Our ref: HA/2017/119246/01-L01
Your ref: BR/80/17/PL
Date: 11 April 2017

**PROPOSED NEW DETACHED 1 NO. TWO BED BUNGALOW ON LAND SOUTH OF
HIGHCROFT CLOSE, BOGNOR.**

**NPA - LAND EAST OF PUMPING STATION HIGHCROFT CLOSE, BOGNOR REGIS,
WEST SUSSEX, PO22 8DS.**

5070/2

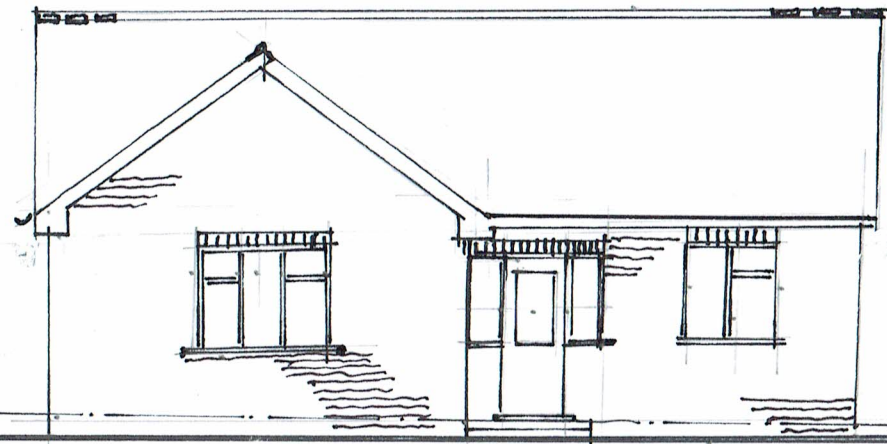
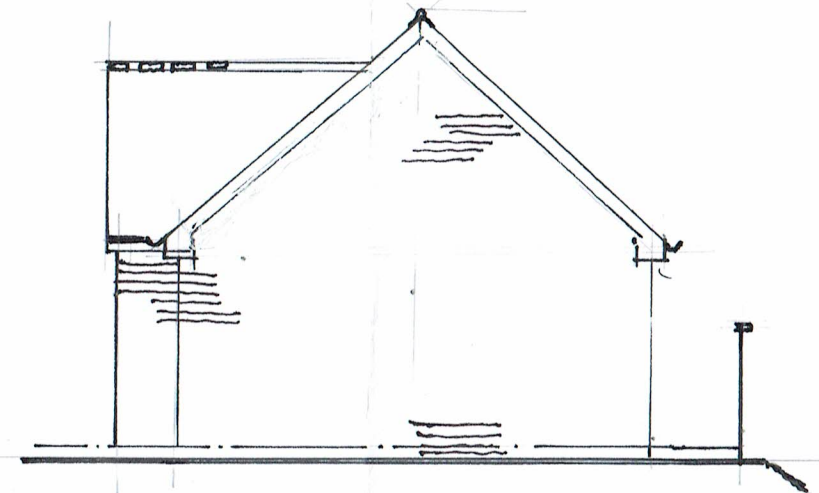
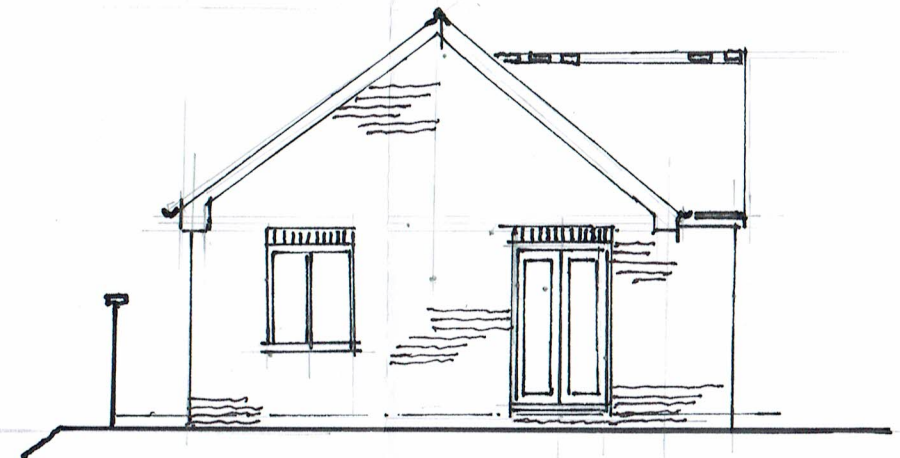
The proposed development will only meet the requirements of the National Planning Policy Framework if the following measure as detailed in the Flood Risk Assessment (August 2016) submitted with this application is implemented and secured by way of a planning condition on any planning permission.

The development permitted by this planning permission shall only be carried out in accordance with the approved Flood Risk Assessment (FRA) (August 2016) and the following mitigation measure detailed within the FRA:

- Finished floor levels are set no lower than 2.65m above Ordnance Datum (AOD)
